Attachment A – New Public School in Mulgoa Rise, Glenmore Park – Response to additional agency comments

Agency and Issues	Response
Penrith City Council	
<p>The Department is urged to have strong regard to the need to ensure (in line with the Premiers Priorities and the Minister's recently issued Planning Principles), the need for high levels of canopy tree planting and green streets, Council raises that regard is to be had to Council's previous comments provided in cover letter dated 1 October 2021 including:</p>	
<p>(i) It is critical that planting within the front setback at this location is proposed where there are no street trees (also refer comments below in relation to street tree removal and recommended actions). The development of the site shall achieve and provide continuous canopy tree planting around the periphery of the development to screen the hard stand / manoeuvring area associated with the waste facilities.</p>	<p>The Landscape Design contained in Attachment D provides a continuous tree canopy has been provided to street frontages where possible. However, there is an opportunity to provide a staggered tree alignment to further increase the tree canopy and screenin

Drawing Title
SITE PLAN

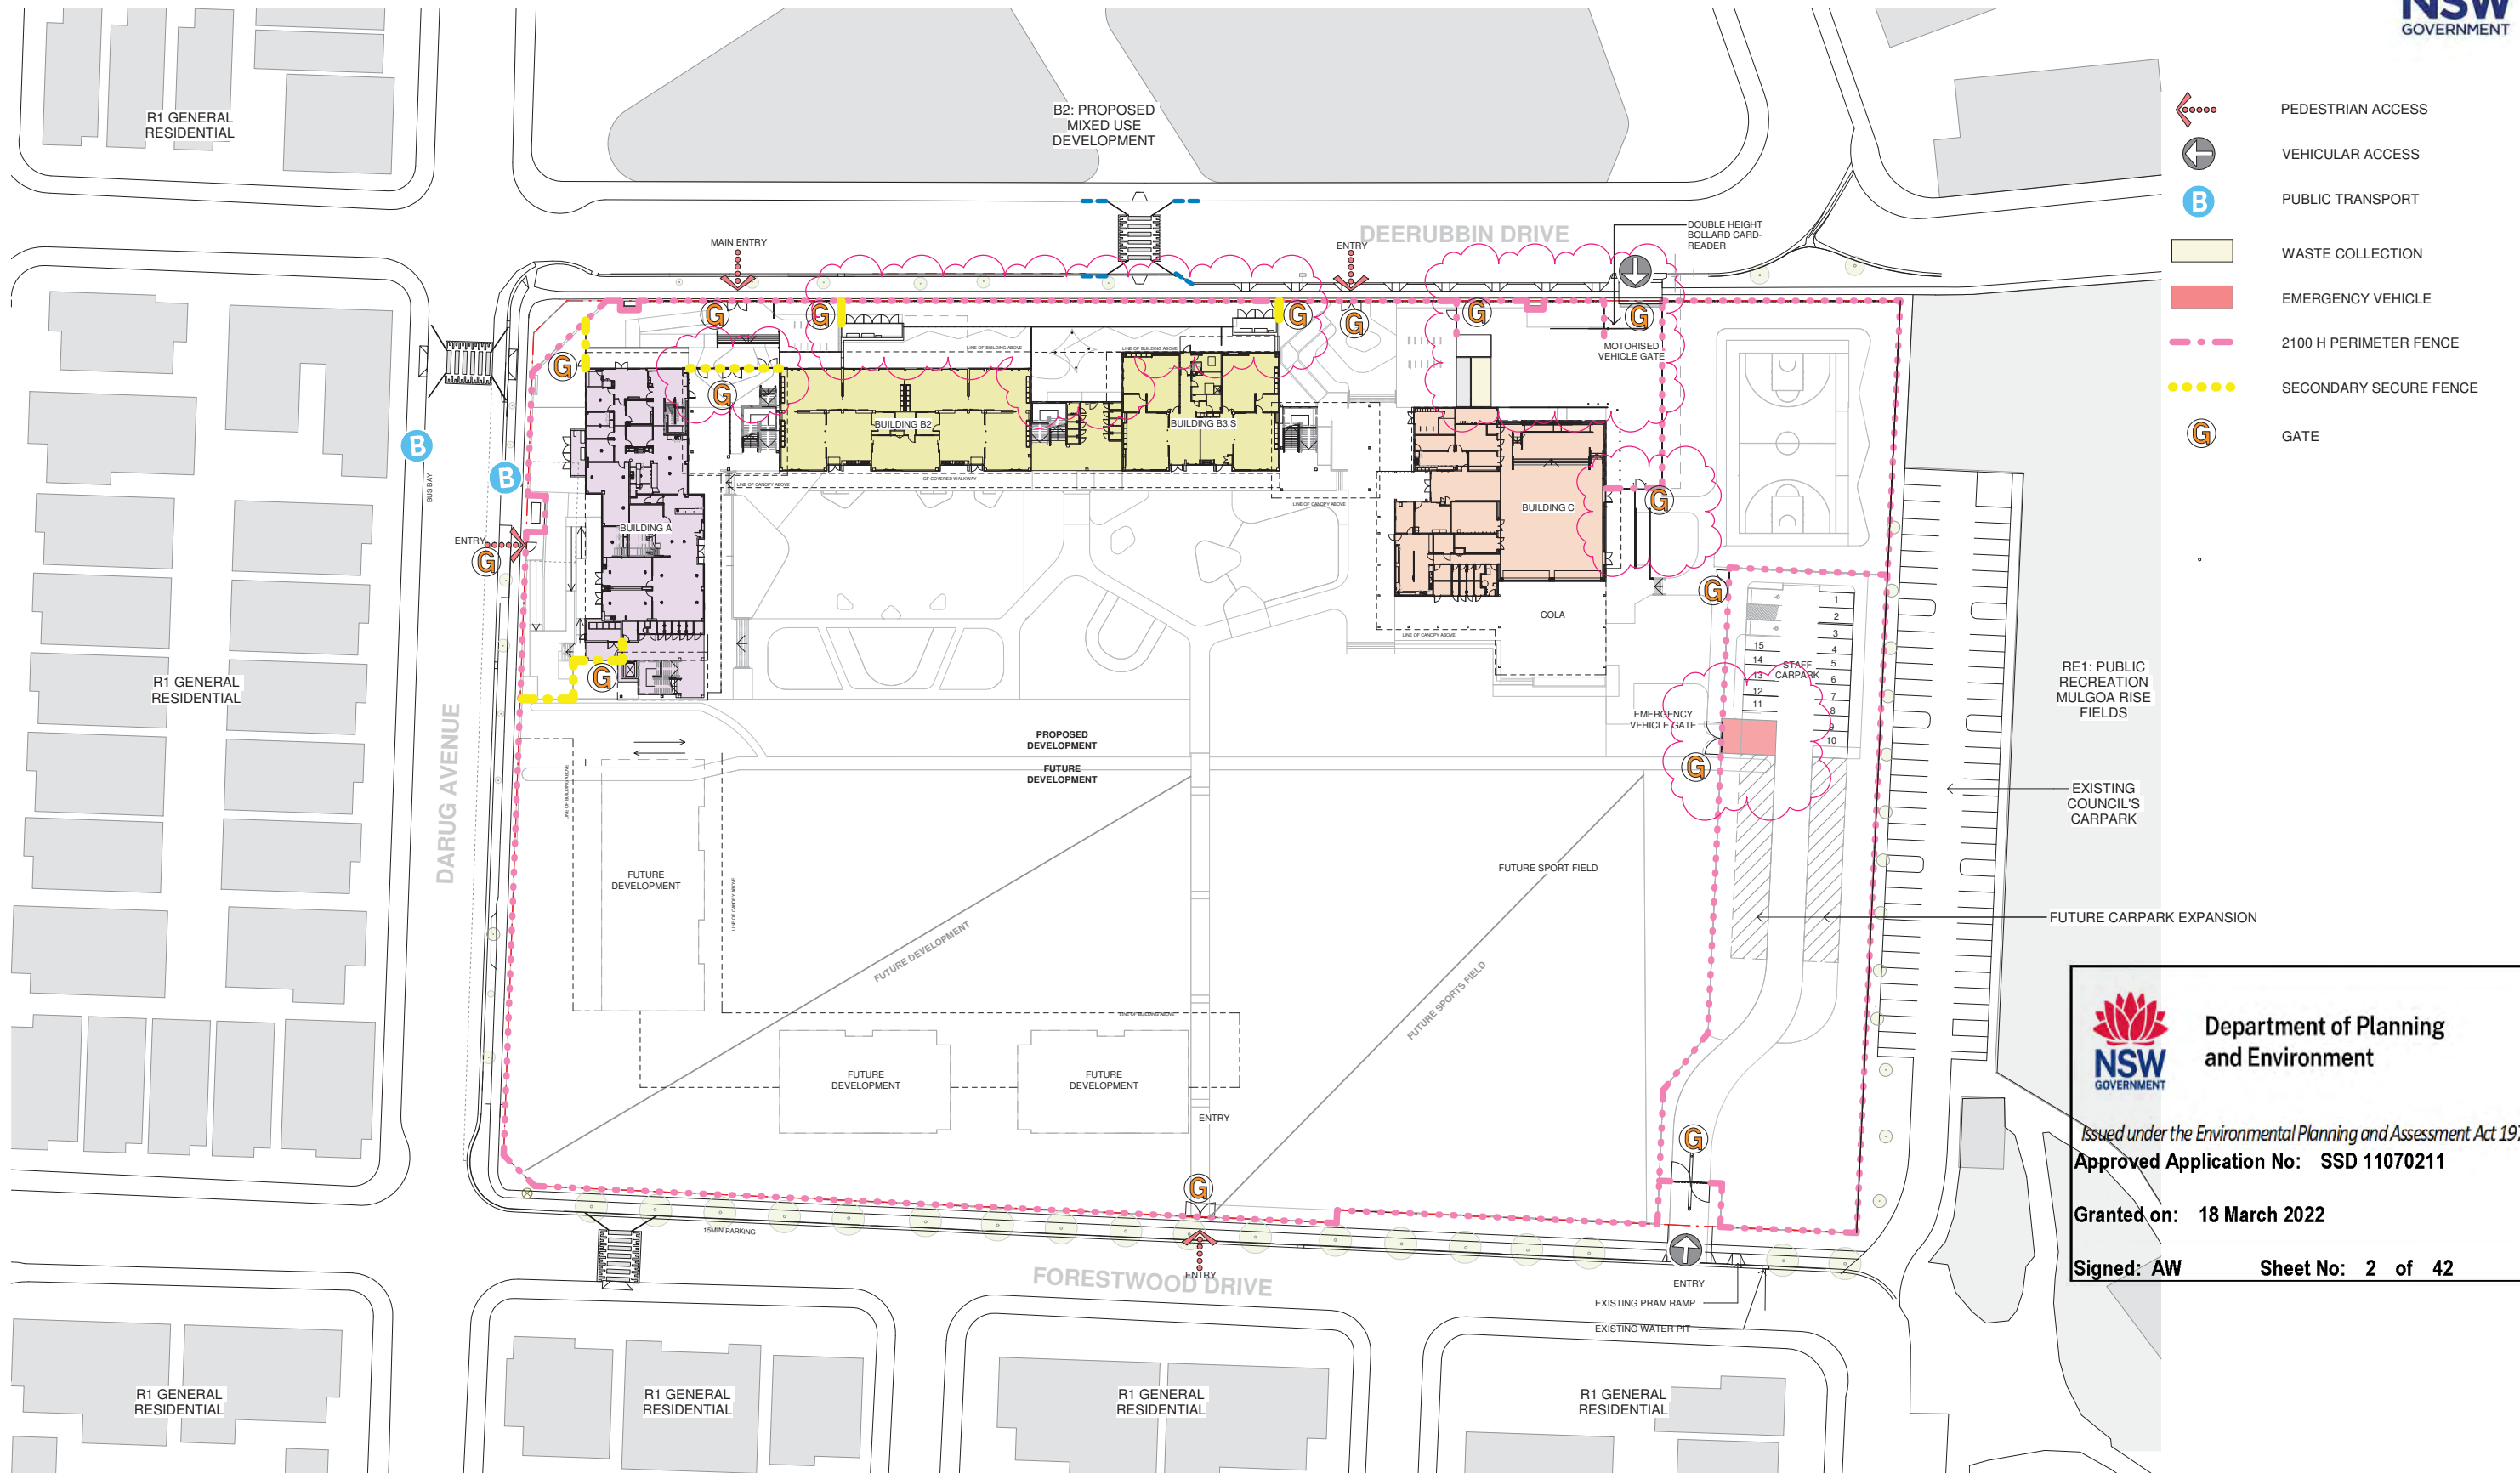
<p>(ii) The plant and infrastructure should be relocated away of the frontage location and could be reorientated and relocated to the east of the waste / loading area.</p>	<p>The two remaining services apparatus located along the boundary line of Deerubbin Drive are the Fire Booster Valve cabinet and the water meter. These 2 spaces are required to be located on the property boundary. All other plant and infrastructure spaces have been set back from site boundary. Refer to the previously reissued Architectural drawing no. SSDA-0110 (rev 11). A condition in relation to relocation of plant and infrastructure is not warranted.</p>
<p>(iii) It has previously been raised that the application foreshadows additional parking for Stage 2 works. It is inappropriate to push back the delivery of necessary parking. All parking must be provided up front as part of the stage 1 works. This will negate unnecessary reliance on the public road network for parking and reduce potential overflow into Council's adjacent car parking facilities.</p>	<p>As mentioned within the submitted RtS, car parking generated by the next stage of development will be provided for in future development applications when required. The proposed number of parking spaces has been assessed against the requirements of AS2890.1:2004, with reference to Class 1A (employee) facilities. The School Transport Plan (STP) included in the Transport and Traffic Assessment (TTA) promotes active transport to the site, supporting mode shares and sustainable management of the transport needs of staff and students to the development to reduce the need for onsite parking. By providing parking as proposed, a culture of active transport usage will be realised from the commencement of school operation and will be ingrained in the culture of the school community.</p> <p>A condition requiring additional parking is not warranted.</p>

Drawing Title
LANDSCAPE SITE PLAN
SCALE: 1: 750 @ A3

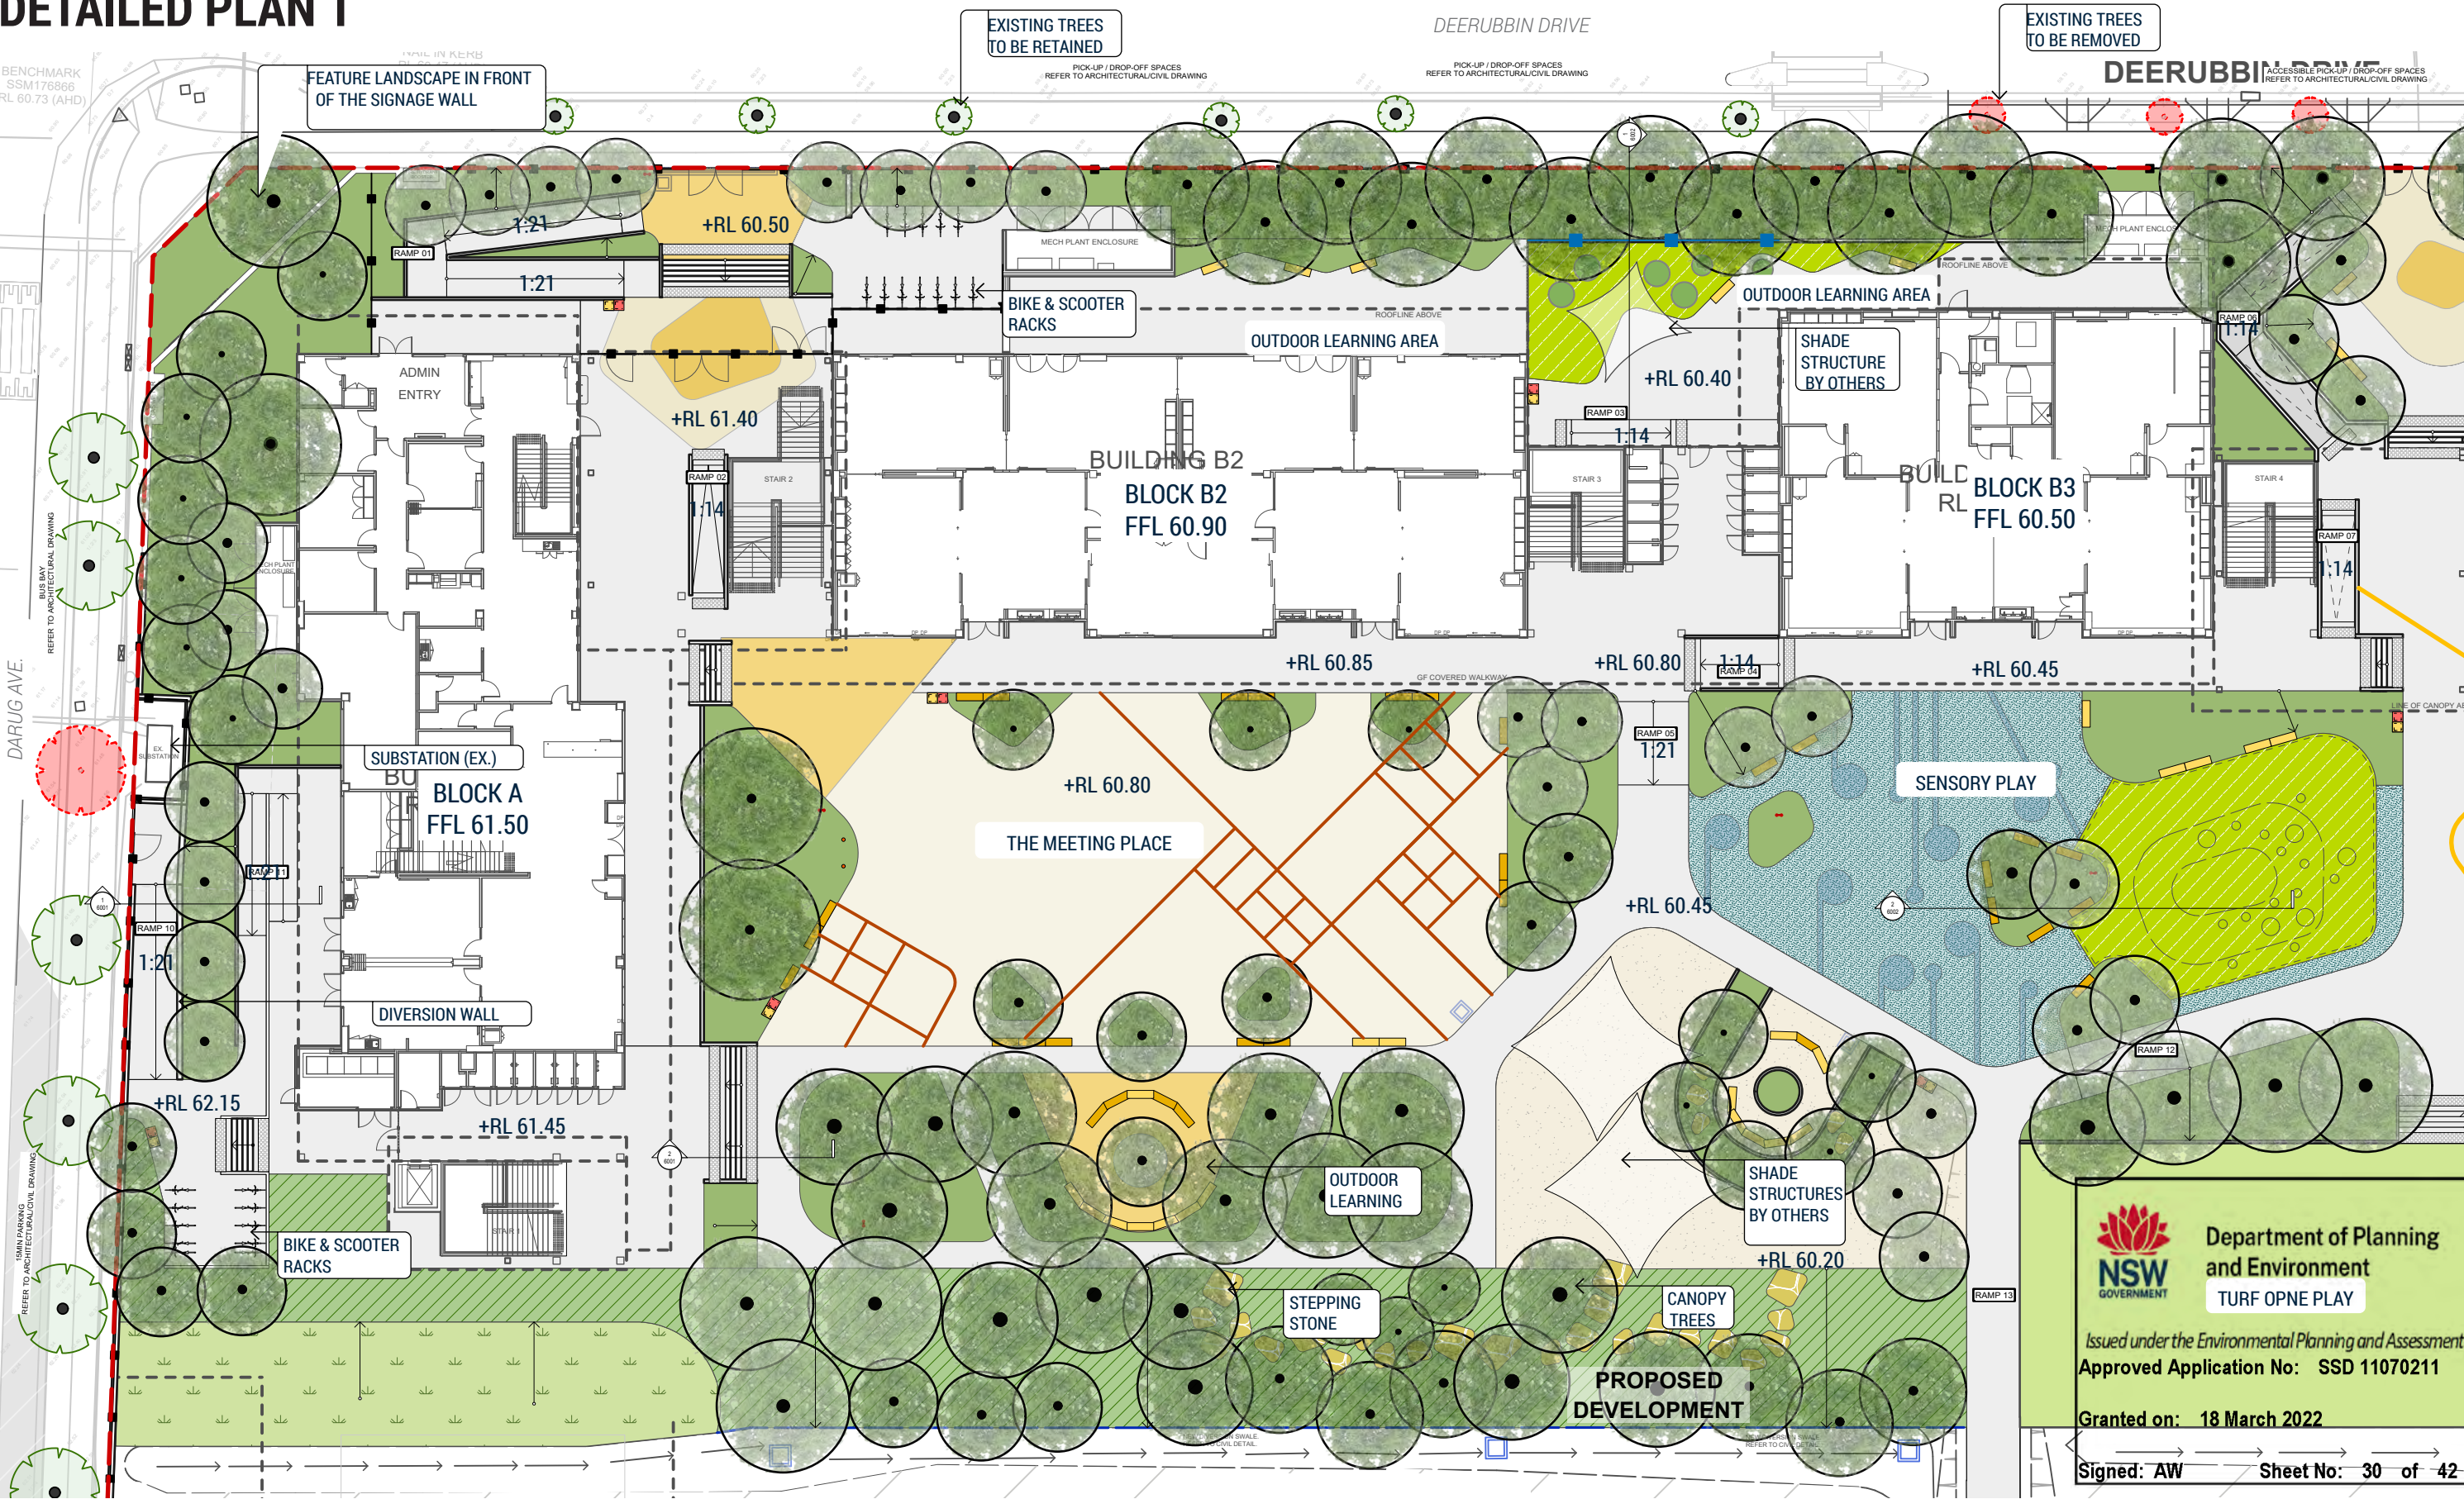
<p>Street trees are proposed to be removed to enable accessible parking bays. These street trees should be replaced at a 2 for 1 ratio. Council supports street trees of a suitable size above and below ground in between kerb ramps at accessible parking bays. Additional street trees should be considered in the verge north of playing courts.</p>	<p>A greater than 2:1 ratio is achieved along Deerubbin Drive and the remaining area of the proposed development. Tree planting along Deerubbin Drive has been adjusted, refer to Attachment D, to be a staggered line of trees and the inclusion of an additional 7 trees. Street tree planting within the verge north of the playing courts will be contemplated with future expansion of the school and subject to separate planning approval. In addition, the future stage of the school will incorporate comprehensive landscaping.</p>
<p>To further support amenity in the streetscape and wayfinding, the site corner has capacity for large feature trees in association with walls and signage.</p>	<p>The Updated Landscape Design Drawings show a feature tree (<i>Araucaria cunninghamii</i>) located next to the signage wall as wayfinding element.</p>

<p>Consistent with Council's Cooling the City Strategy, a continuous and effective street tree canopy is preferred. Street trees should be planted in accordance with Council's Street and Park Tree Management Plan and Appendix. Protection of existing street trees to be retained should be in accordance with Australian Standards and documented.</p>	<p>Noted.</p>
<p><u>Tree Canopy Cover</u></p>	
<p>There is a lack of detail regarding tree species and the corresponding canopy dimensions on the plan. Whilst the canopy cover appears to meet targets, large tree species are not identified on the plan, nor their mature canopy spread represented on the plan.</p>	<p>Drawing L-SSDA-0010 Planting Zone Plan (Attachment D) provides the locations of tree planting across the site. This corresponds with the planting schedule provided on sheet L-SSDA-0011 Planting Schedule – Trees (Attachment D). The canopy dimension shown on the Planting Zone Plan is based on an average mature canopy dimension to account for variance in growth. Large canopy trees are located away from building awnings where possible to minimise the impact on maintenance.</p>
